Your Ref: OWPC4220
Our Ref: BE/130/14/HH 15-10-2014
Please ask for:
Mrs J Chapman

Flat roof rear extension & new gable to main roof with flat roof dormer
25A Central Avenue Bognor Regis

Elevations as Proposed

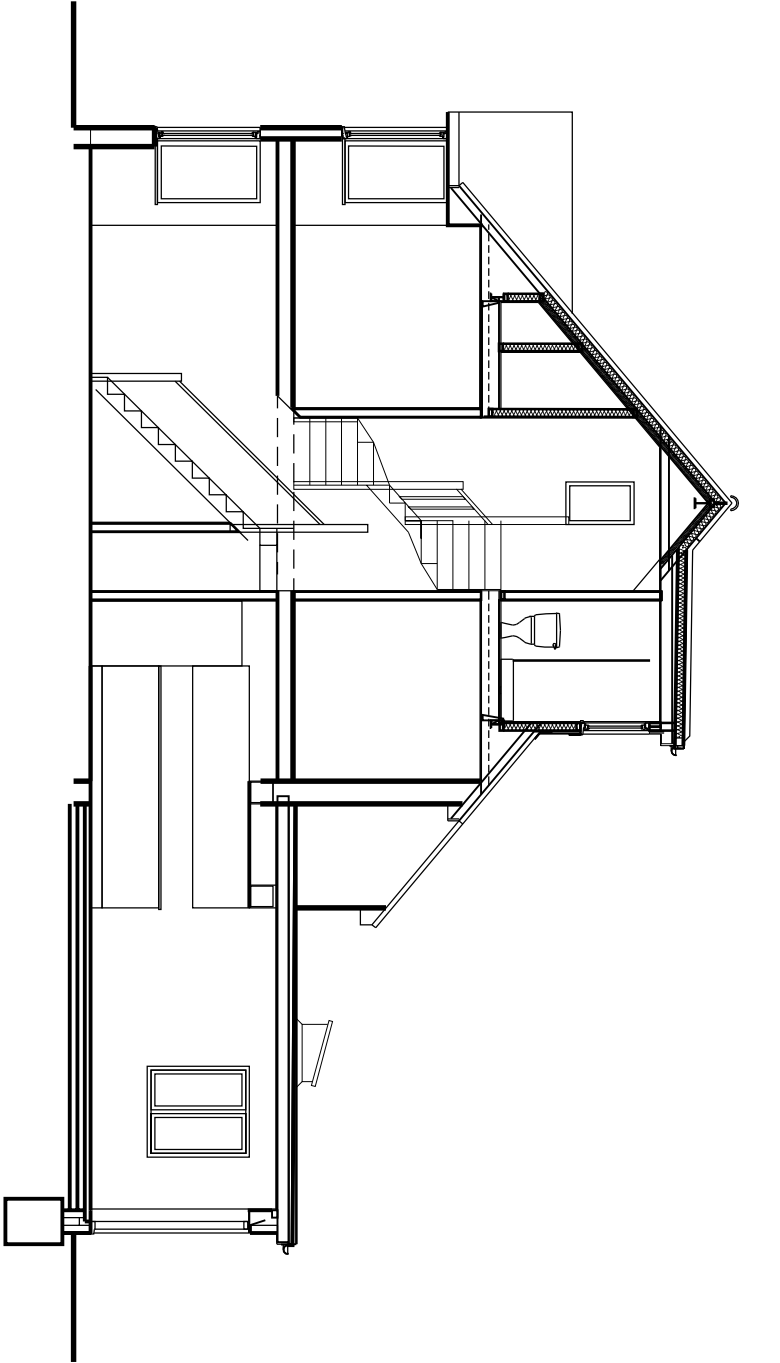
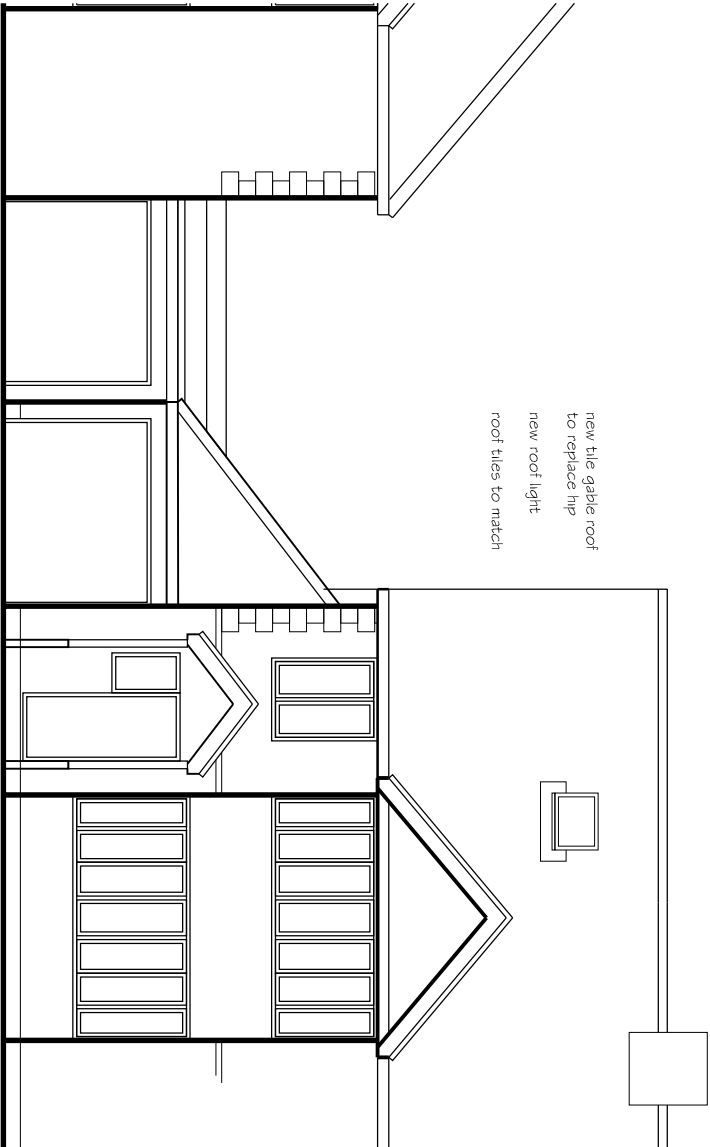
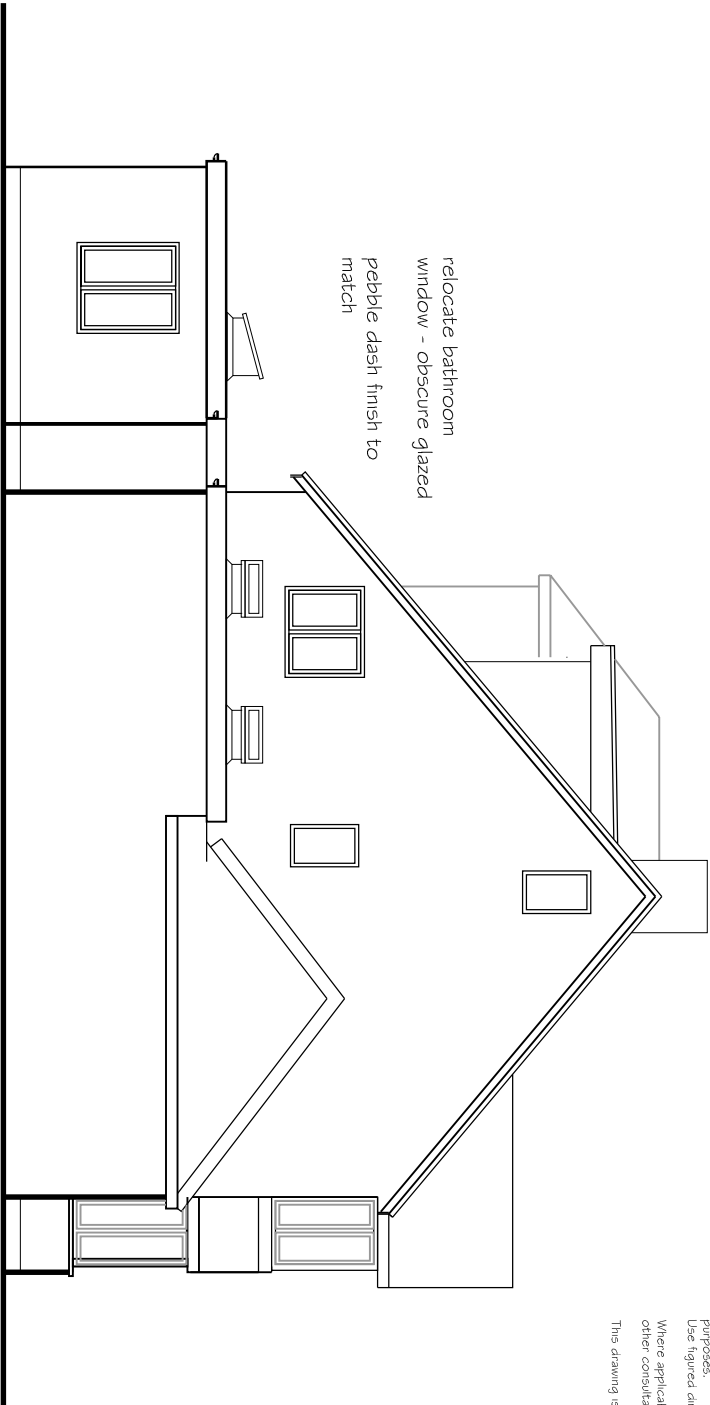
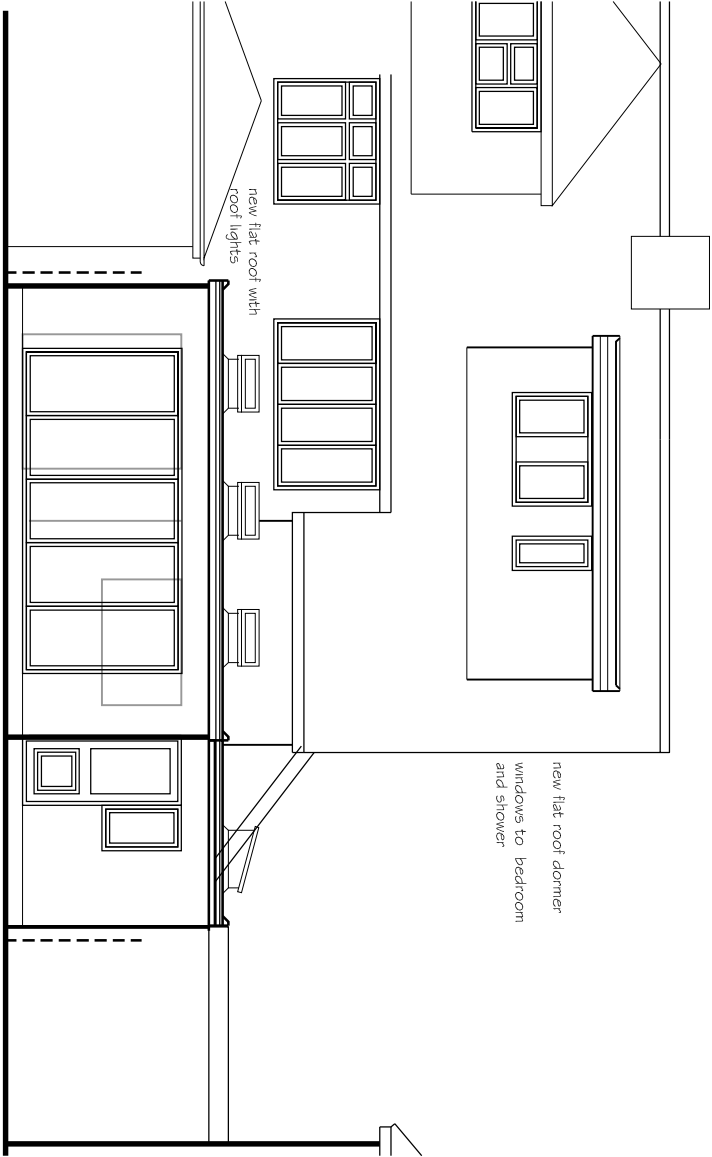
Firstly I wrongly assumed that planning application had to be posted so that neighbours were given some notification. As this has not been the case I am having to quickly reply and my objection is to the gable roof and the restriction of sunlight and shade it will cause to our property. The close proximity of the houses will plunge our bathroom and landing windows into instant shade. Also we have recently had a solar tube fitted to our north facing kitchen to gain more natural daylight and the gable roof proposed will again negate the advantage of this due to its close proximity. We have north facing gardens and already live with a lot of shade in our lives and so every little bit of sunlight is precious.
